Recommendation Report for Planning Permission for Works or Extension to a Dwelling

REF NO: FP/206/21/HH

LOCATION: 10 Old Manor House Gardens
Felpham
PO22 8QR

PROPOSAL: Single storey front porch/garage extension

Title
Proposed Site and Floor
Plan

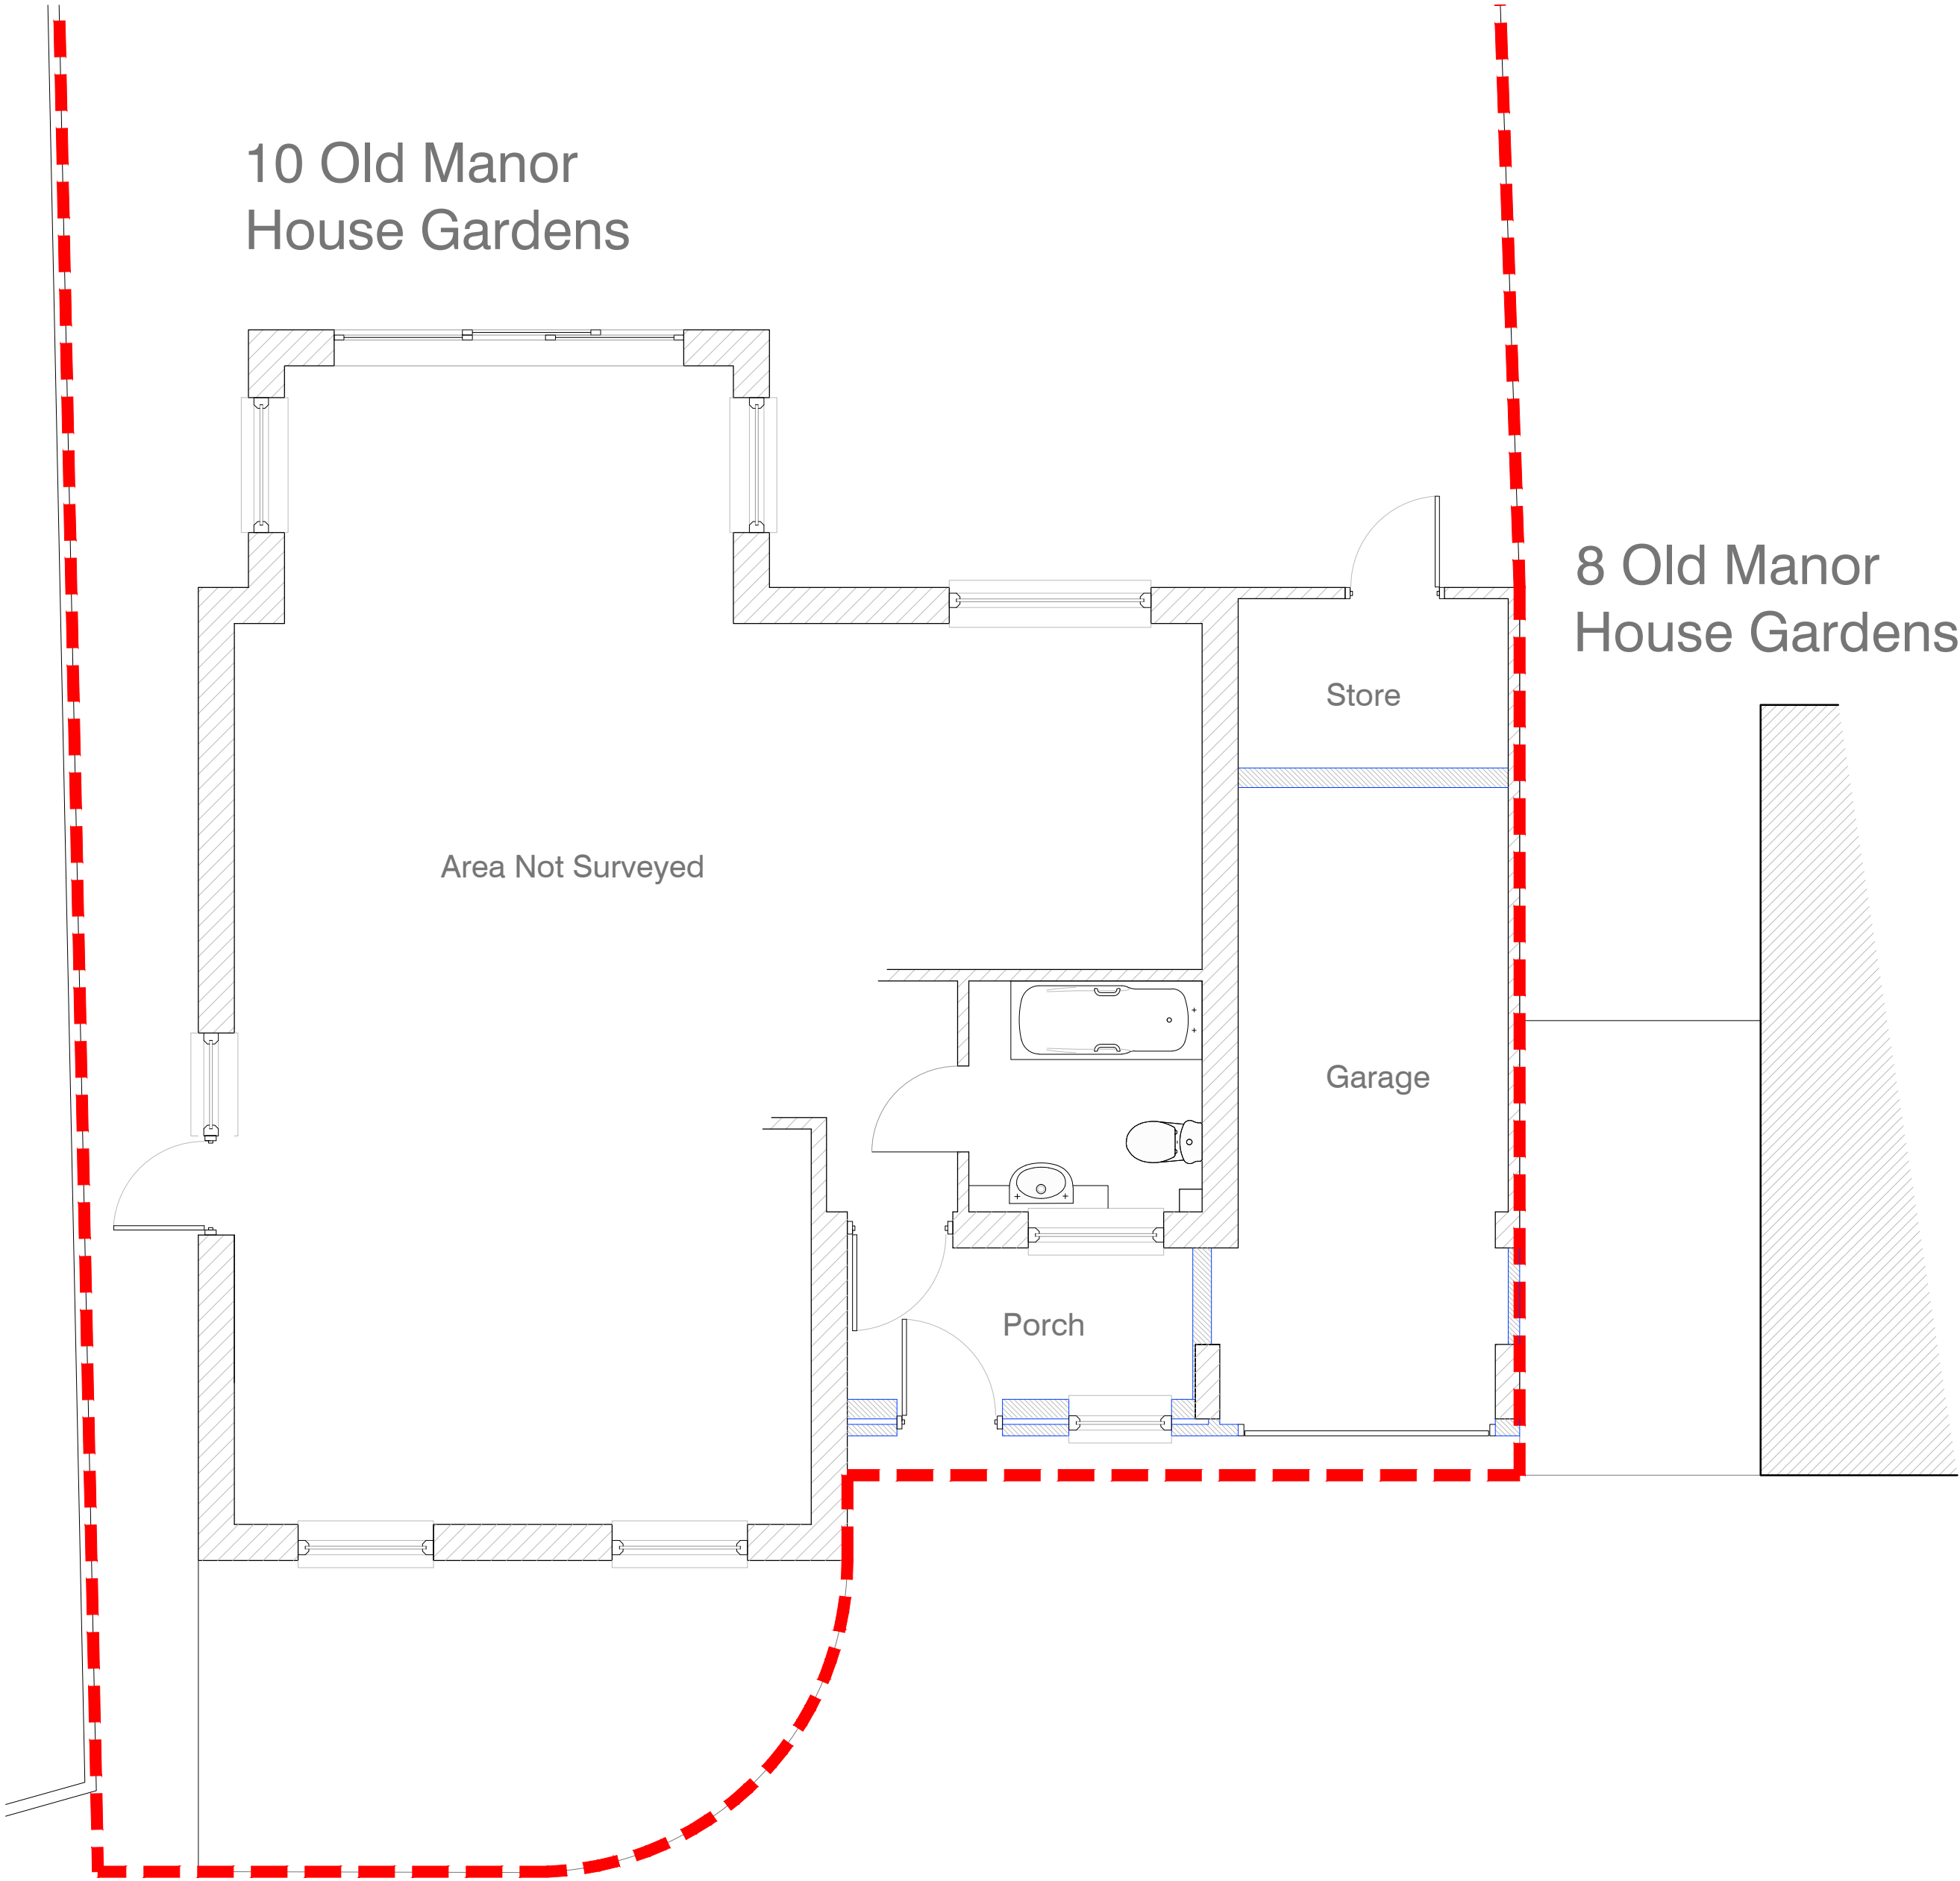
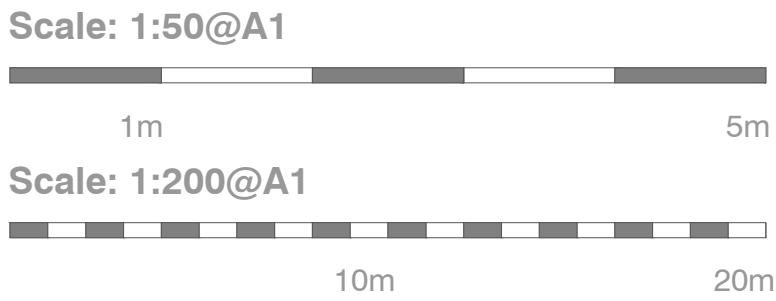
There is a covered area which runs along the front of the dwelling forming an open porch. The proposal seeks to enclose this and the development does not extend beyond the existing principal elevation. This has a depth of approximately 1.65m which meets with the gable front.

Due to the siting to the front of the property and with it retained within the existing footprint, it is not considered to result in adverse overbearing or overshadowing upon amenity.
